Appeal Decision

Appeal Ref: APP/R5510/W/25/3361540

177 Station Road, West Drayton UB7 7NQ

- The appeal is made under section 78 of the Town and Country Planning Act 1990 (as amended) against a refusal to grant planning permission.
- The appeal is made by Mr Jag Rai against the decision of the Council of the London Borough of Hillingdon.
- The application ref. is 47713/APP/2024/3109.
- The development proposed is conversion of 8 bed HMO to 9 bed HMO.

MASONWOOD DESIGN
 client Mr Jag Rai
 project 177 Station Road, West Drayton, Hillingdon UB7 7NQ
 drawing PROPOSED GROUND + FIRST FLOOR PLANS
 date Nov. 2024
 work stage 3
 scale 1:100 at A3
 drawing no D11
 project no 2024.013
 revision -

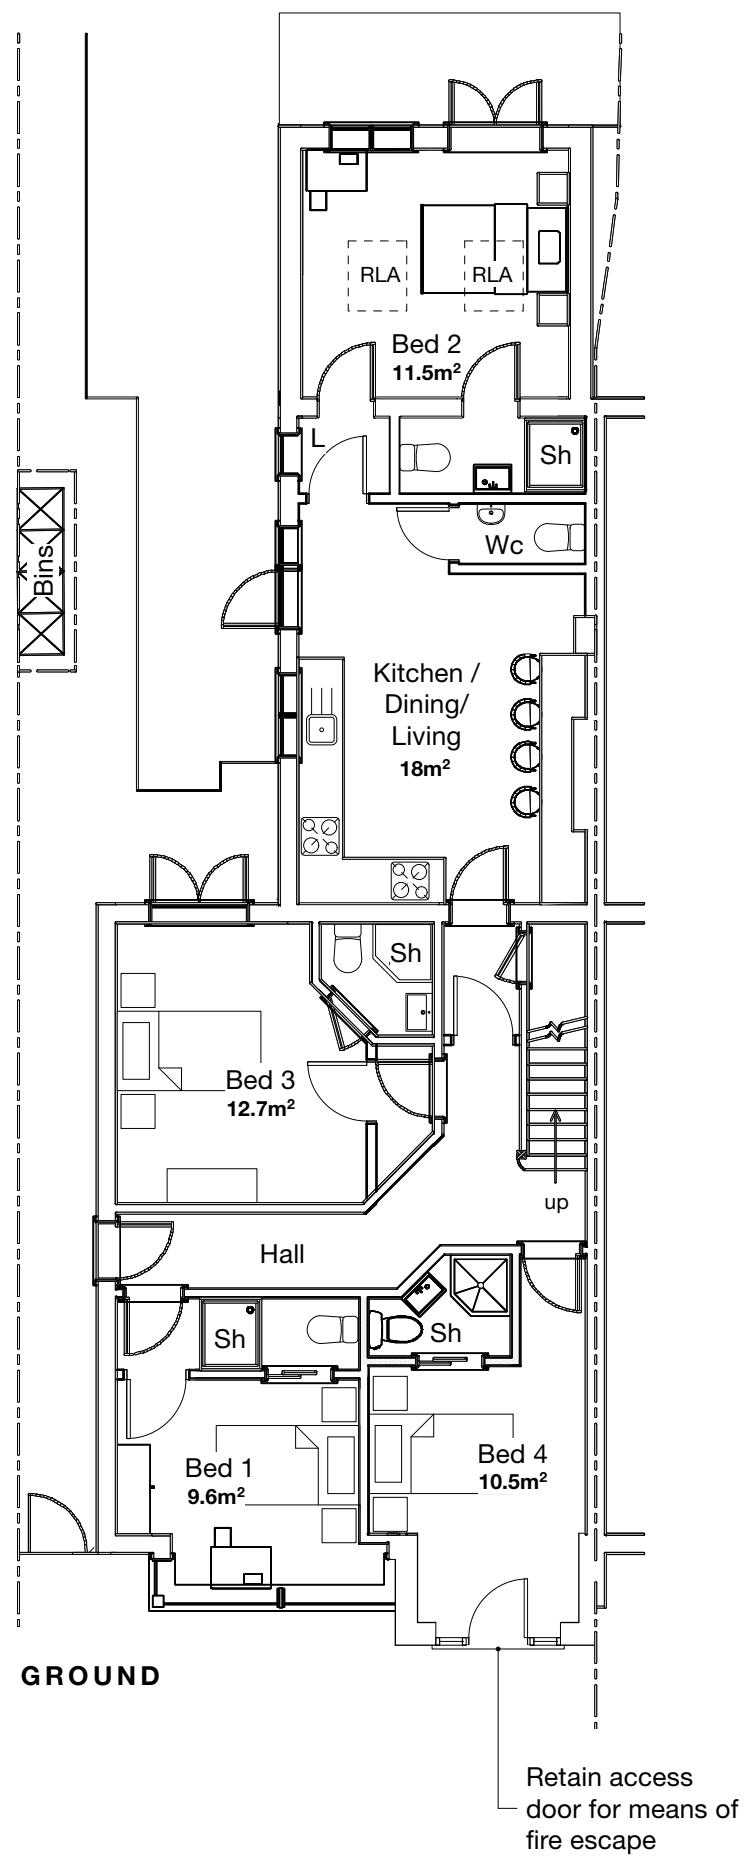
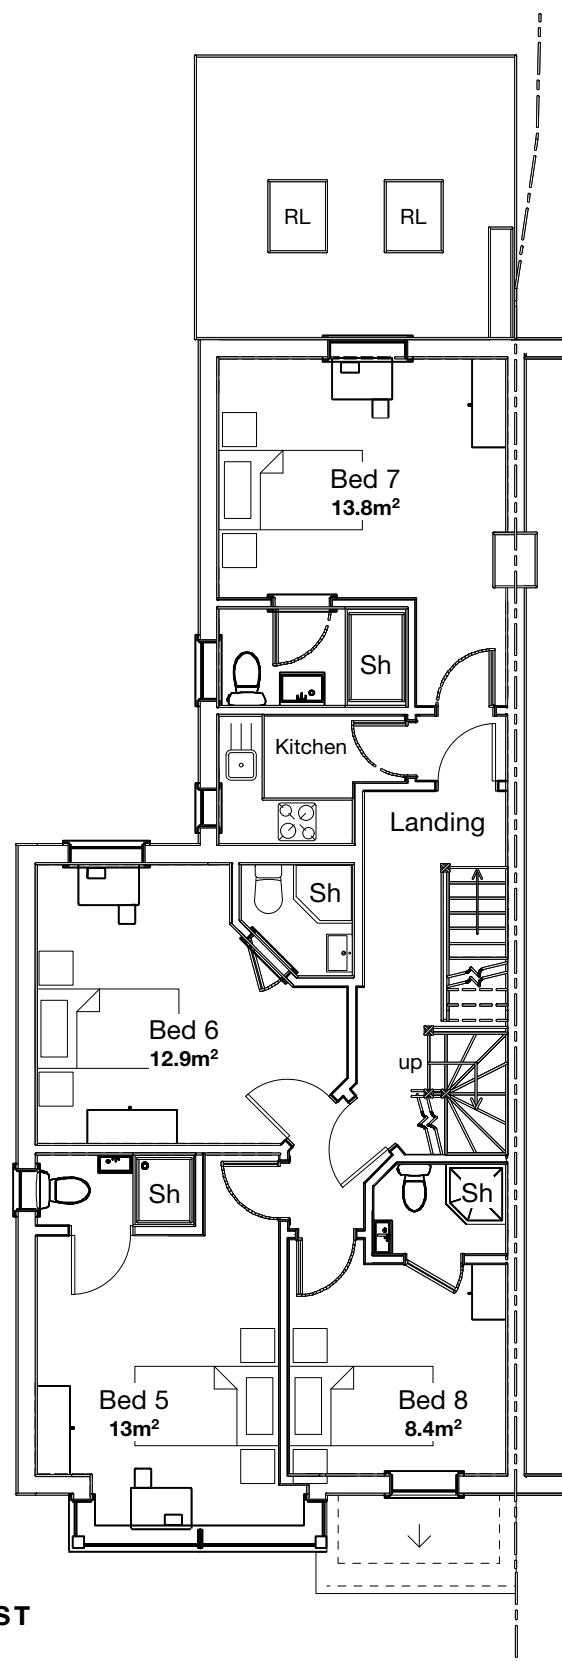
4. The house has been converted into an eight-bedroom house in multiple occupation (HMO), licenced for up to 16 people in nine households. Permission exists to erect a porch, which would extend what was part of the hallway and is now a communal study area containing the original front door. The appeal proposal would convert the communal study area into a further bedroom.

5. To accommodate 16 people, all but two of the bedrooms would have to be double occupancy, for which the minimum internal space standard set by Policy D6 of the London Plan (March 2021) is 11.5sqm. The drawings indicate that three would be below that standard on implementation of the porch extension and the proposed change of use. The proposal would also have the effect of reducing the communal amenity space available to residents of the HMO.

6. This would leave an 18sqm kitchen, dining and living area on the ground floor and a 3.7sqm kitchen on the first floor. The drawings indicate that the outbuilding, which is 22.5sqm in area, would be used as a secondary communal area. However, this

is some way from the house and is unlikely to be used, particularly during winter months. Overall, about 44.2sqm of communal amenity space would be left for an HMO of about 190sqm, or 212.5sqm including the outbuilding.

7. The standards at Policy D6 of the London Plan 2021 increase by about 9sqm for each additional person, the largest being 138sqm for a 6-bedroom, 8-person, 3-storey dwelling. Whilst not directly applicable in this case, this would suggest a standard of 210sqm for a 16-person 3-storey dwelling. The proposal would only meet this were the outbuilding included. However, as I have found, this would not be convenient as communal space and unlikely to be so used.

8. Therefore, the proposal would increase demand on reduced and less convenient internal communal amenity space and would not provide an adequate standard of living accommodation for future occupiers. This would be contrary to Policy D6 of the London Plan (2021) and Policies DMH5 and DMHB 16 of the London Borough of Hillingdon Local Plan Part 2 - Development Management Policies, which require satisfactory living conditions and adequate internal space.
